Your Ref: OWPC17986
Our Ref: M/41/18/HH 22-03-2018
Please ask for:
Zac Denton

Extension to 1st floor incorporating rooms within the roof space for new 2nd floor & single storey rear extension with balcony above.

25 Sea Way Middleton-On-Sea

PROPOSED ELEVATIONS

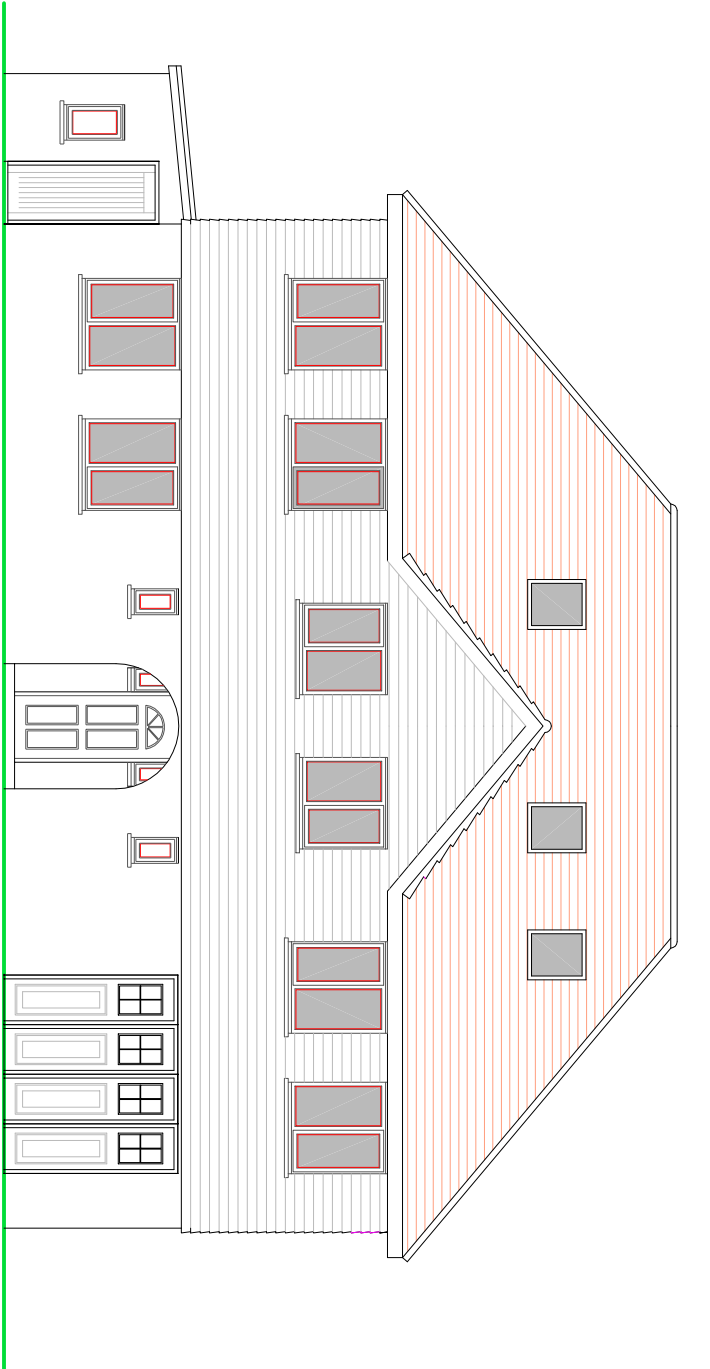
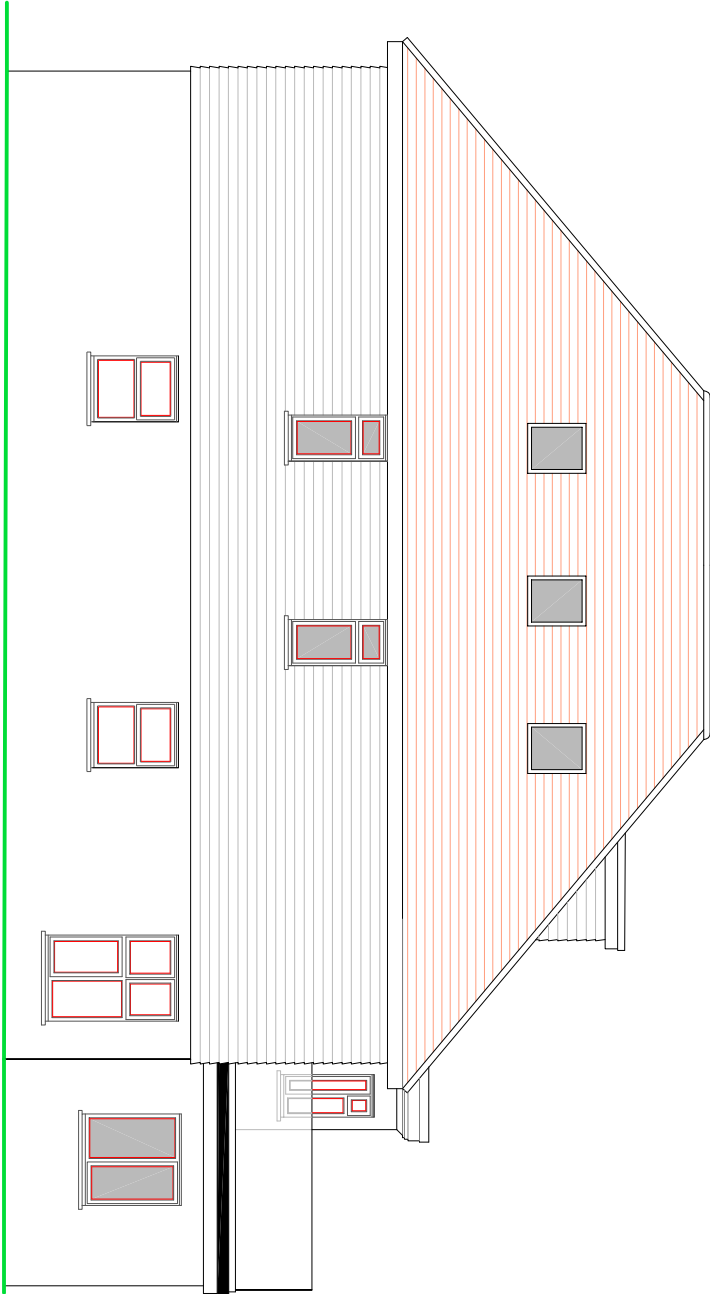
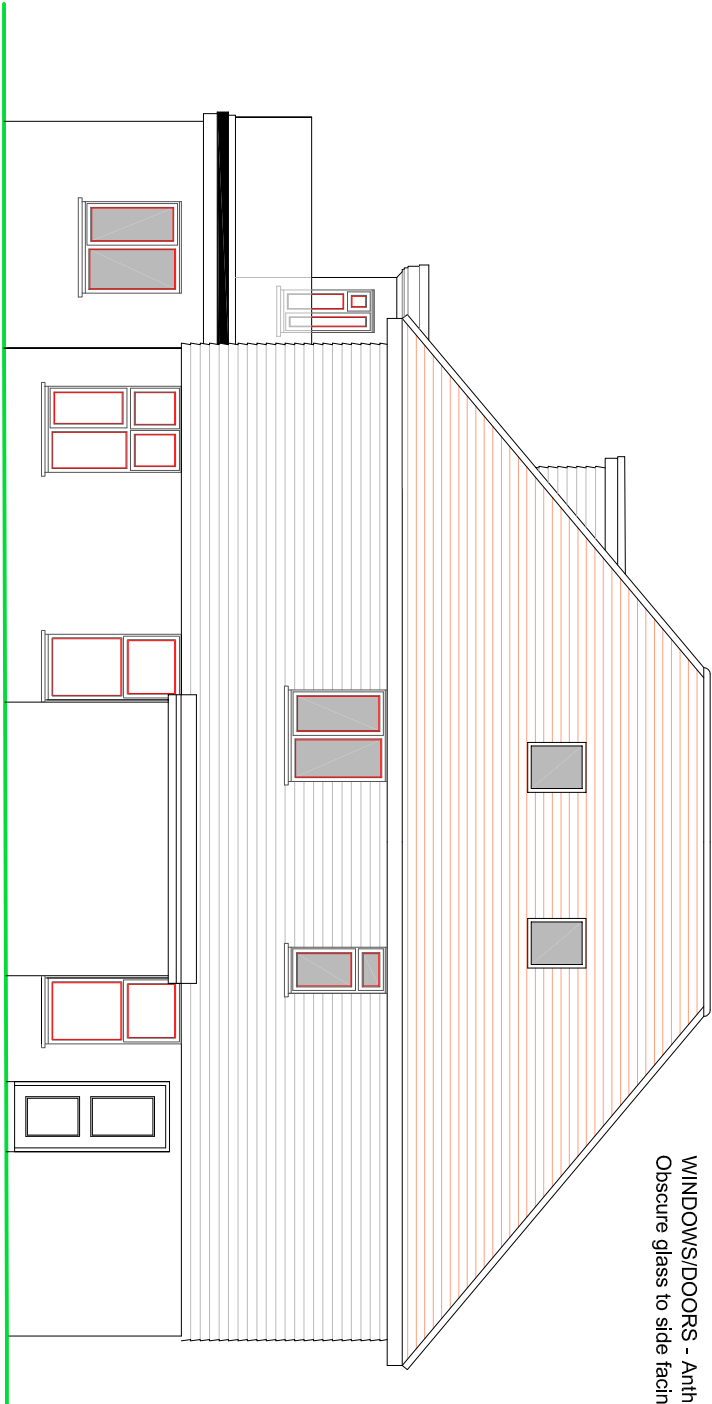
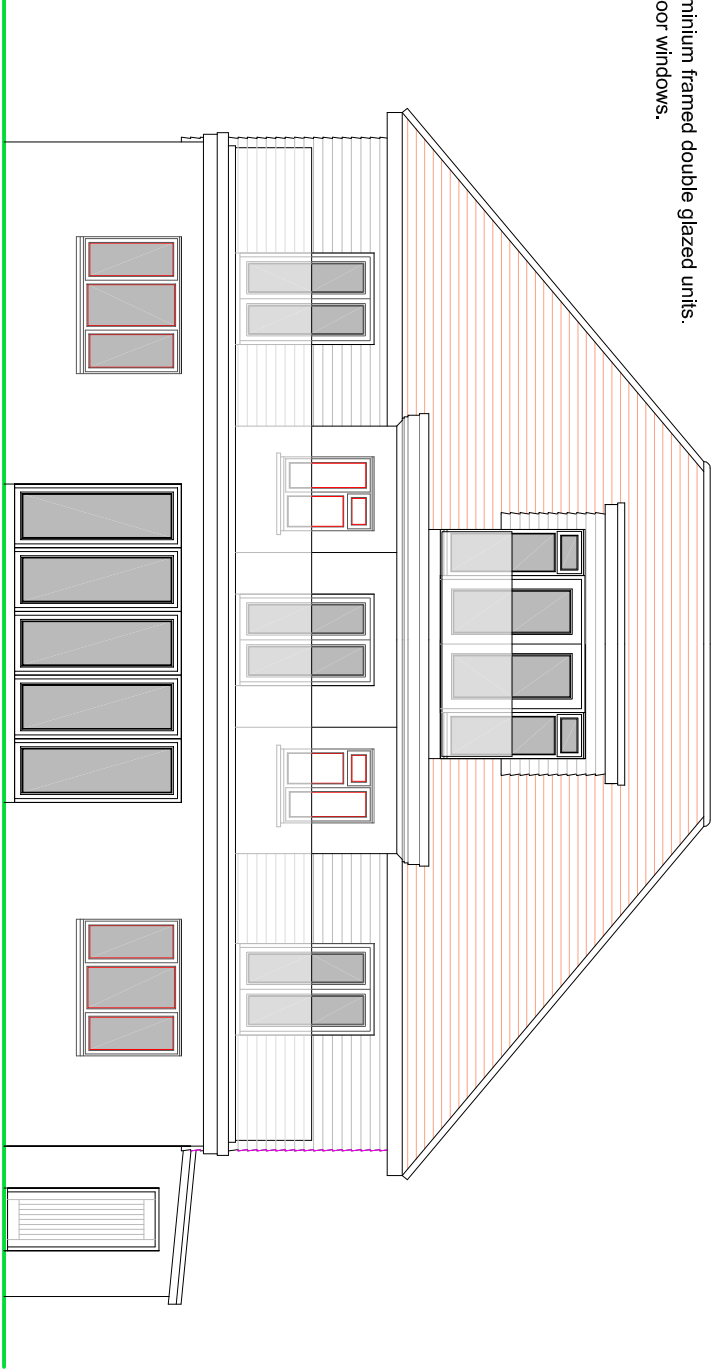
- 1. The size of the property, in terms of its elevation, appears to be increasing by about 15% from the full double floor structure that it currently is. I am sure that we will not be alone in feeling that this is out of keeping with the immediate area and will be overly prominent when compared with the other houses nearby and will stand out disproportionately when viewed from the greensward, neighbouring properties and the northerly side of Sea Way.*

- 2. Second the increase in the size of the house is significantly disproportional to the size of our property (which is a two floor dwelling). The proportional increase in the elevation, when compared to the elevation of our property will make this house 25%-30% higher than our property with the natural concerns around how this affects our privacy, the overbearing nature of being adjacent to such a large structure and the general enjoyment of our property.*

- 3. The submitted plans appear to include a balcony on both the first and second floors of the property. We ourselves have a roof terrace on the first floor of our property and many other properties in the area have balconies. We have no objection at all to the proposed first floor balcony other than we do wonder whether it is right that it should run all the way across the full length of the first floor (as it appears to do) given that this may add to the privacy/overlooking concerns. However the second floor balcony is I am sorry to say highly objectionable in terms of our privacy and is also completely out of keeping with houses in the area. I believe I am right in saying that no other property has a second floor balcony - not only because I understand that third floor dwellings are not a feature of this area but also because of the privacy concerns that overlooking adjacent properties from such a height naturally give rise to.*
